RE: Raising Cane's Chicken Fingers  
4800 Montgomery Blvd. NE  
Albuquerque, NM 87109  
Architect Response to Final Round of Review Comments

Confirmation must be provided that the Building Design requirements of 5-11(E) of the IDO are being met in a comment response letter and/or on the elevations. Staff could not discern that the requirements are being met per the EPC Staff Report, EPC Site Plan Amendment submittal, and EPC Final Site Plan Sign Off submittal.

**SOUTH/DRIVE THRU ELEVATION**

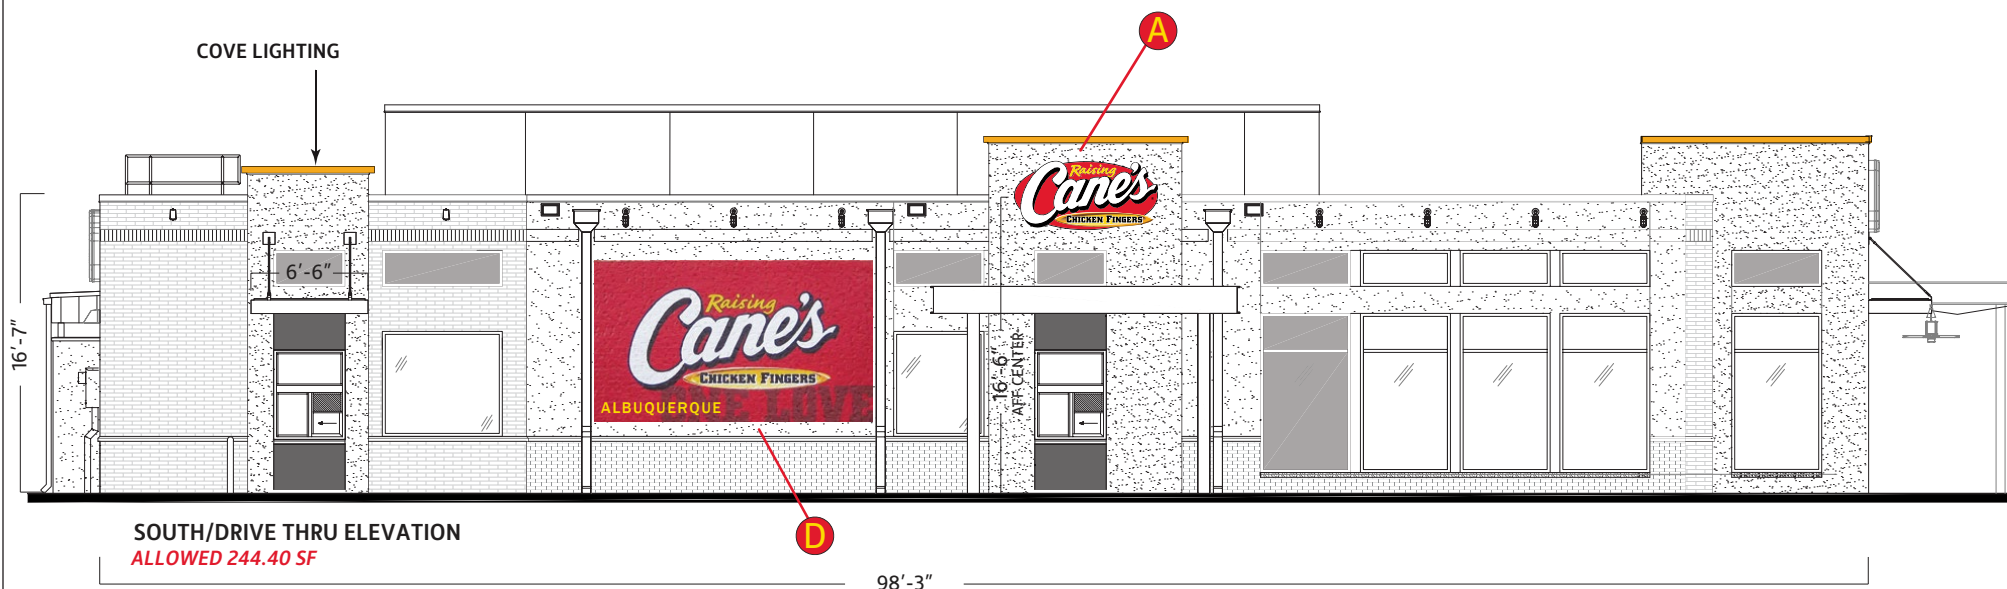
7. Must follow IDO section 5-12 for Signs, both Freestanding and Wall signs, even if painted on building, must meet percent of façade requirements (15% for MX-M zone).

North/ DT Elevation – 1629 SF total elevation \* 15% of facade = 244.35 SF Total Signage per Elevation  
Total Square Footage of Sign on South Elevation is 169.25 SF

South/ Side Elevation – 1629 SF total elevation \* 15% of facade = 244.35 SF Total Signage per Elevation  
Total Square Footage of Sign on South Elevation is 62.75 SF

East/ Rear Elevation – 806 SF total elevation \* 15% of facade = 1120.85 SF Total Signage per Elevation  
Total Square Footage of Sign on South Elevation is 32 SF

West/ Front Elevation – 806 SF total elevation \* 15% of facade = 120.85 SF Total Signage per Elevation  
Total Square Footage of Sign on South Elevation is 48.88 SF
